Our ref: AN/2022/133243/02-L01
Your ref: EN010116
Date: 30 November 2022

Application by North Lincolnshire Green Energy Park Limited for an Order Granting Development Consent for the North Lincolnshire Green Energy Park Deadline 1 Submission (Summary of Relevant Representation)

Figure 7: Graphical representation of CHP and Carbon Capture Envelope

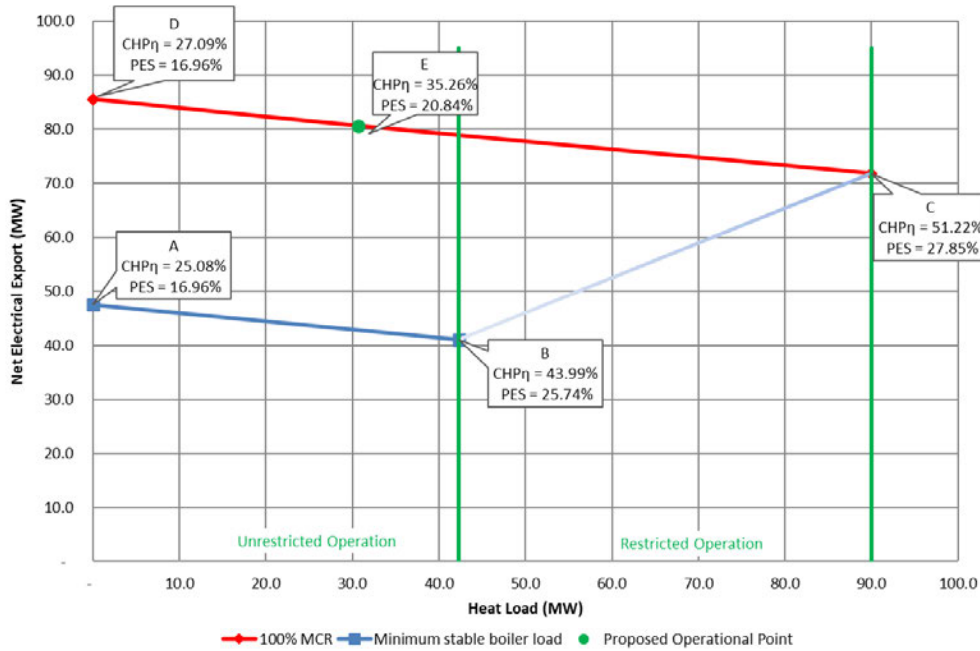
1. the Landscape and Biodiversity Plans (including the Management and Monitoring Plan) and assessment are satisfactory;
2. the Combined Heat and Power assessment covers economic issues and identified end users but does not appear to include information regarding Carbon Capture Readiness. We note that this proposal is to have Carbon Capture Usage and Storage (CCUS) from the outset and if this issue is covered in the ES, we would be grateful if the Applicant could signpost us to the relevant parts for this assessment;
